DISAPPROVED
Plan Review
07/31/2019 1:22:35 PM
dsdarchuleta
EPC Planning & Community
Development Department

MATTHEW & CARISSA JOHNSON RESIDENCE
1335 MONTCOMBE DRIVE, MONUMENT, COLORADO 80132

DRAWN: ASL
DATE: 4/4/2019
JOB NO.:
SHEET NO.: **C1**

C1

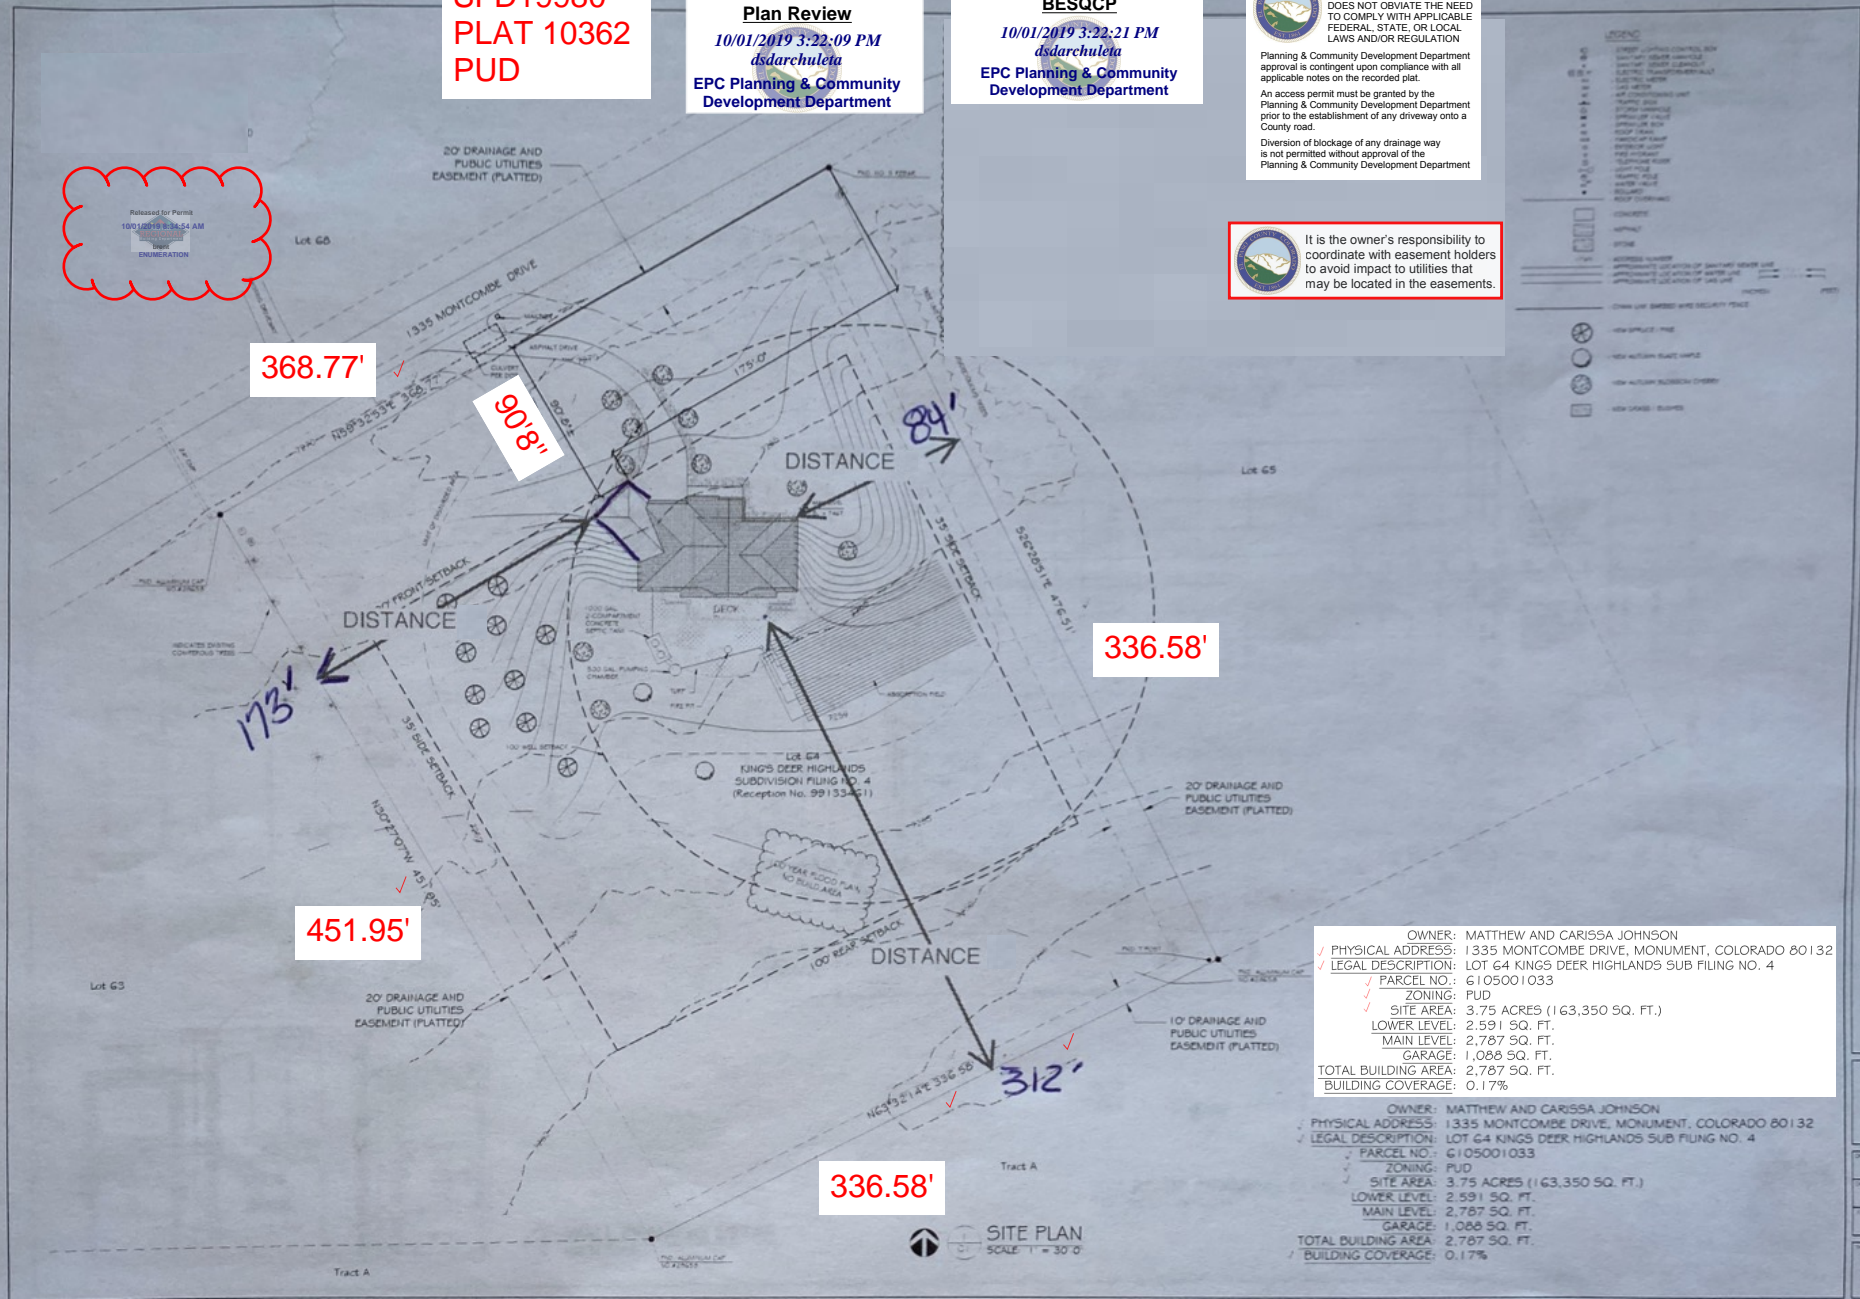
DISAPPROVED
1) MISSING DISTANCE MEASUREMENTS OF PROPERTY LINE
TO STRUCTURE FOUNDATION
2) REQUIRE PREBLE MOUSE - APPROVAL TO BUILD FROM THE
U.S. FISH AND WILDLIFE SERVICE (coloradoes@fws.gov)
